**Planning Application Ref:** AW/201/17/T

**Location :** 2 Lichfield Gardens, Aldwick

**Description of works:** Reduce crown of 1 No Weeping Willow tree by 4m

WEeping WILLOWS x2

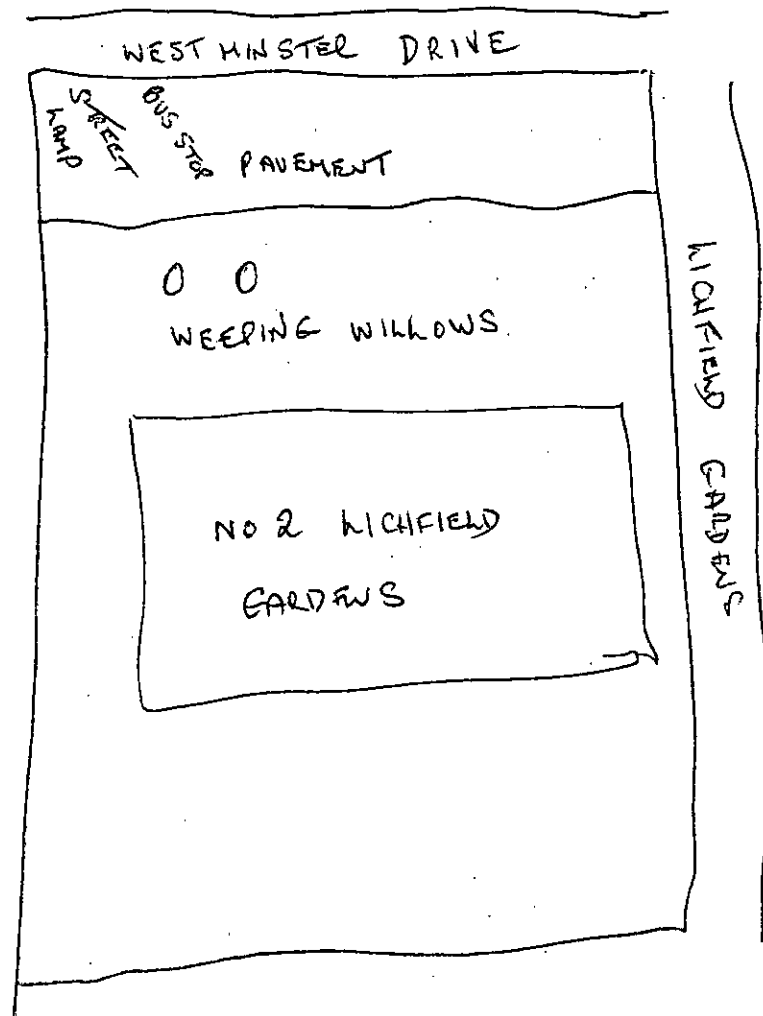
**T 1 – Weeping Willow** *Salix babylonica* Height = 6m Avge spread = 5m Age = Early Mature

- A healthy maturing tree with a very low spreading habit of weeping form touching ground level.
- Sound and healthy and makes an impact in the landscape.
- Pedestrian passage is blocked by the lower canopy.

- The request to crown reduce is effectively cutting back to the previous topping out points.
- I have no issue with this as it will leave the tree safe and it will swiftly replace this growth over a few growing seasons.

- I recommend **APPROVAL** for the works as listed in the application.
